**KIRKLEES METROPOLITAN COUNCIL
INVESTMENT & REGENERATION SERVICE**

DELEGATED DECISION TO DETERMINE PLANNING APPLICATIONS

Reference No:	2025/62/90761/E
Site Address:	15A, Miller Hill, Denby Dale, Huddersfield, HD8 8RG
Description:	Extend existing front and rear dormers, alterations to front elevation, part render to front, side and rear
Recommending Officer:	Faiza Bano

HOUSEHOLDER DELEGATED REPORT

Proposed Front Elevation

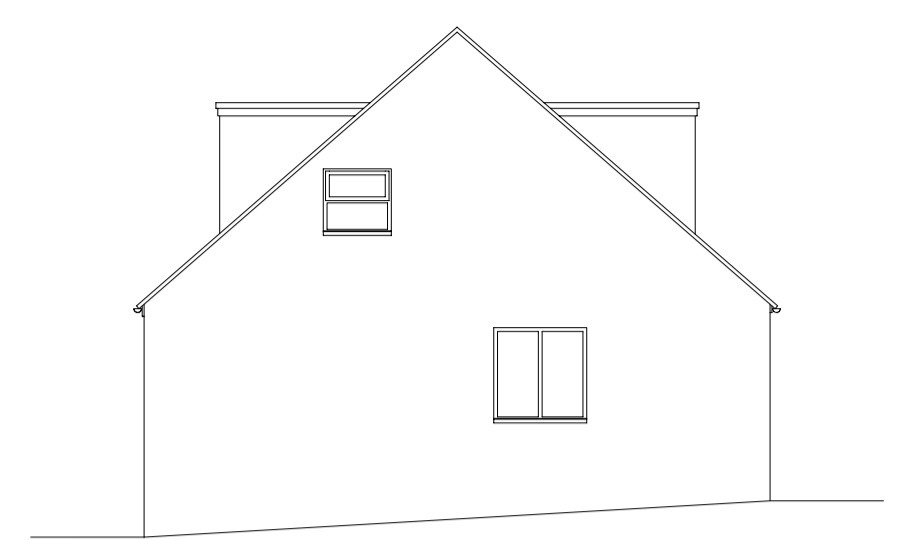
The application proposes to replace the garage door with a new door and window, to extend the hallway. The existing front door will be replaced with a large window.

The replacement door and window, currently occupied by the garage door and existing entry point, is considered to be visually acceptable on the basis the materials match the materials of the dwelling. The proposal would see the application of render to the front, rear and side elevations.

3. The external walls of the development hereby approved shall be of a colour finish to match the walls of the existing building and dormers.

Proposed Ground Floor Plan

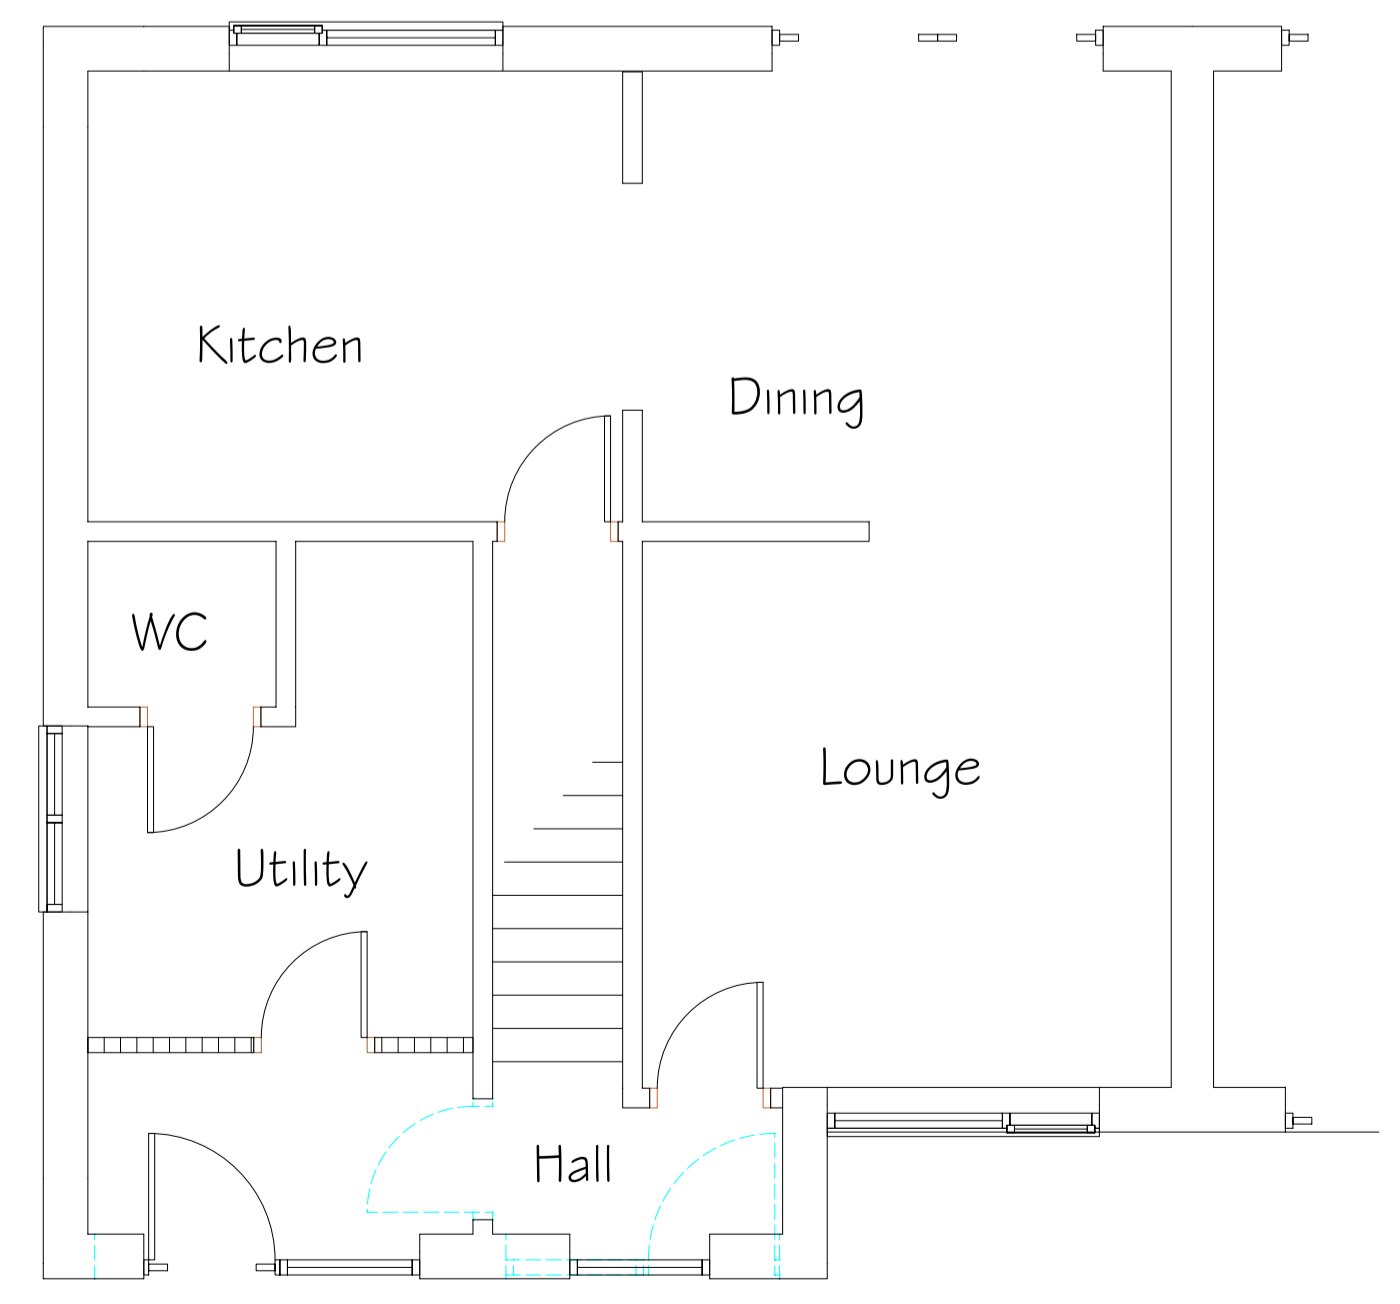
YES / NO	SUMMARY
Negotiations/Amendments during course of application	No	An updated proposed plan (1RevA) was submitted which was provided in response to a request for the proposed ground floor plan to be provided. Given the plans as publicised it was not considered further advertisement of the

Proposed First Floor Plan

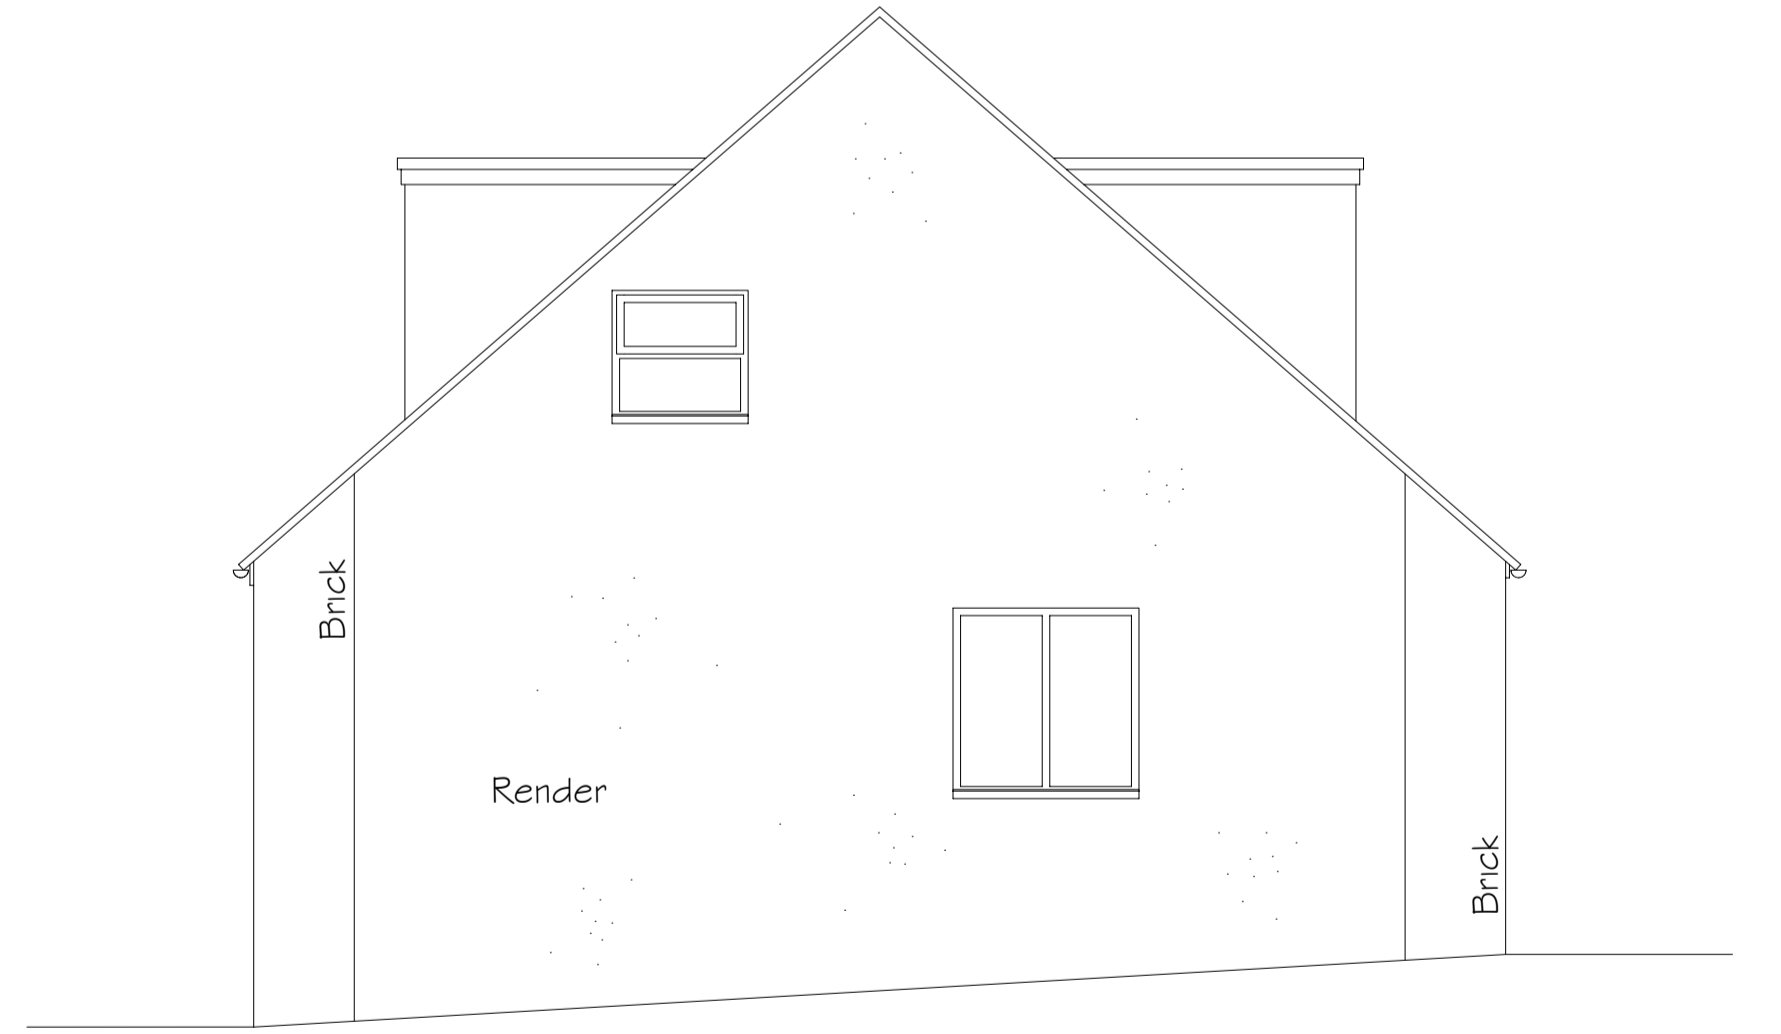
The proposal would see the existing dormer roof openings increased in size and tie into an existing dormer in the rear and an existing dormer / flat roof element of the host property to the front.

1. **Roof Design:** There is uncertainty about whether the dormer roofs will be flat or sloped. The current sloped membrane roof was installed to prevent water ingress, and any changes might affect the integrity of the roof.

Officer Response: The dormers are designed with flat roofs. Although they are termed "flat," these roofs will have a slight monopitch slope to ensure proper drainage and prevent water accumulation. Building regulations would be a requirement for the development and this matter would form part of any building regulations approval.
